Planning Inspectorate

The Infrastructure Planning (Examination Procedure) Rules 2010 – rule 17
Application by SEGRO Properties Limited, for an order granting development consent for a scheme comprising the East Midlands Gateway Phase 2 (EMG2)

The Infrastructure Planning (Changes to, and Revocation of, Development Consent Orders) Regulations 2011 – regulation 44
Application by SEGRO (EMG) Limited, for an order making material changes to the previously approved East Midlands Gateway Rail Freight Interchange and Highway Order 2016

Request for further information

APPENDIX 2: Traffic Flows

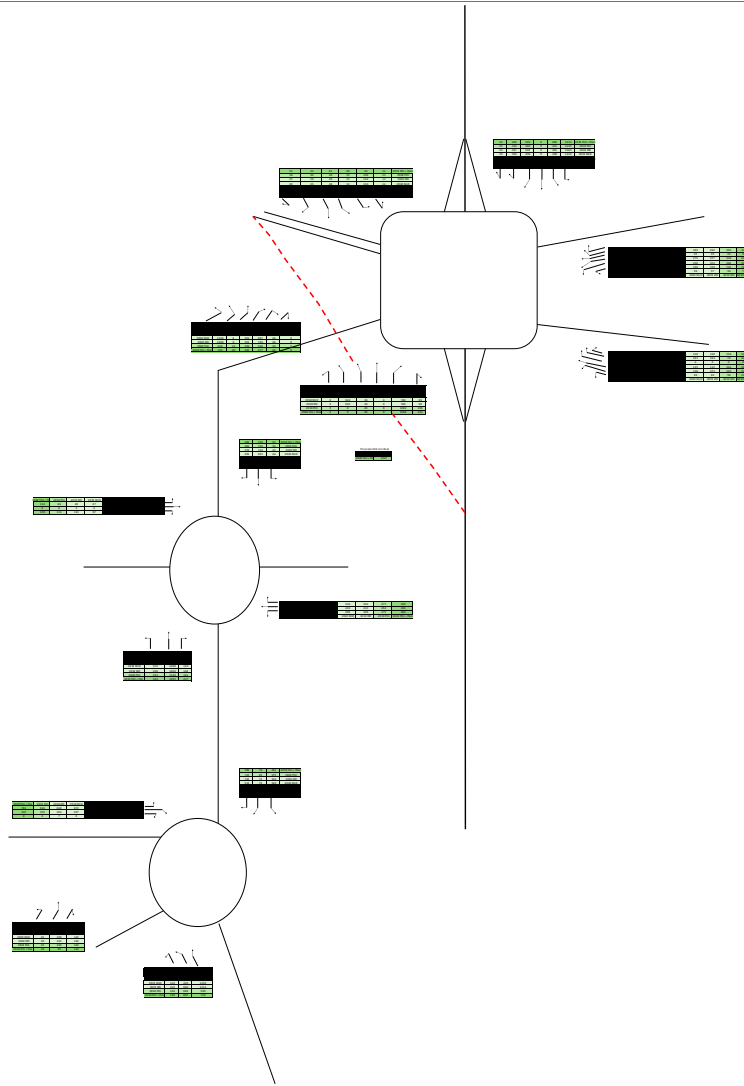
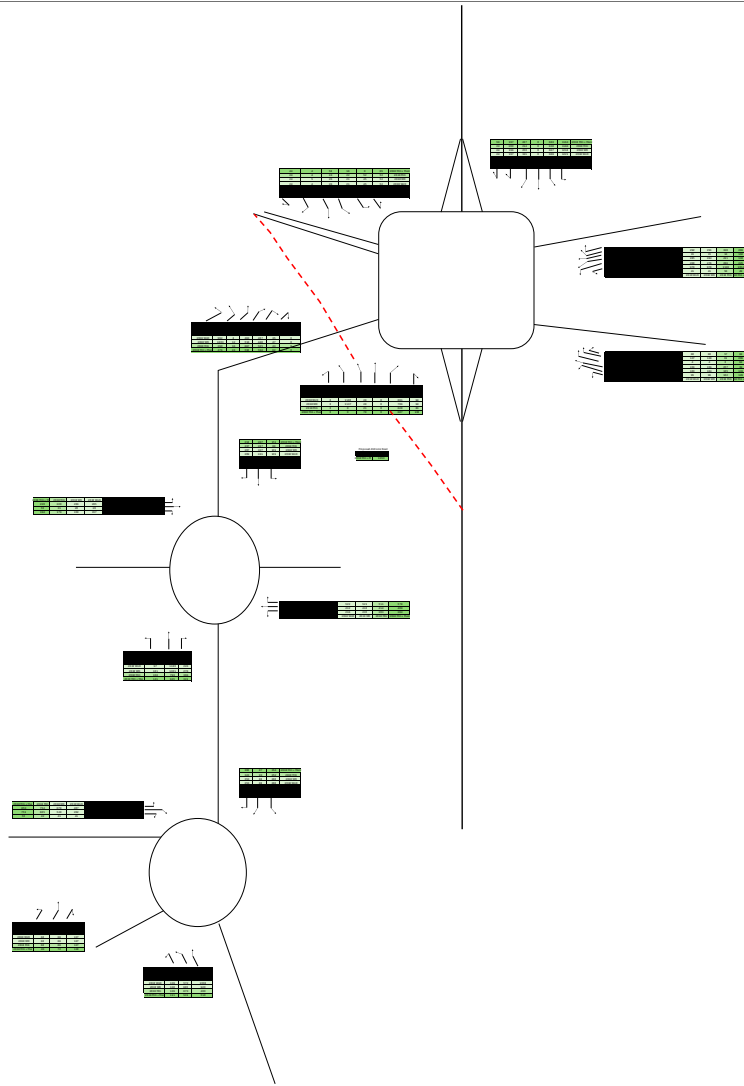
Appendix 50 of the Transport Assessment [REP1-043, pdf page 98ff], VISSIM Forecast Modelling Report, sets out forecast traffic flow diagrams (AM and PM, 2028 and 2038, without development, with development and with development and mitigation). In the D6a submissions the applicant has submitted a 'VISSIM Additional Mezzanine Sensitivity Test Modelling Report' [REP6A-003D] which has similar traffic flow diagrams. It is noted that the latter report does not show any 2028 figures.

Comparing the 2038 traffic flows on the two diagrams the ExP would have expected that the 'without development' flows should be the same. However, they are not. This may be because Appendix 50 uses the 2019 Pan Regional Traffic Model (PRTM) figures and the latest submission uses the 2023 PRTM figures, or for some other reason.

The ExP asks the applicants to confirm the situation explaining in full if the figures should be different.

In the context of Protect Diseworth's representation (see above), it would be beneficial to confirm the applicants' position as to the vehicle flows (in Passenger Car Units) along the A453 to the north of the EMG2 main site, both east and west of the access roundabout in the following scenarios in both the 2028 and 2038 modelled years:

While appreciating the difficulties in providing the diagrams on, effectively, an A4 format, the ExP would appreciate these diagrams to be submitted in effectively an A1 format to allow the figures to be easily read.
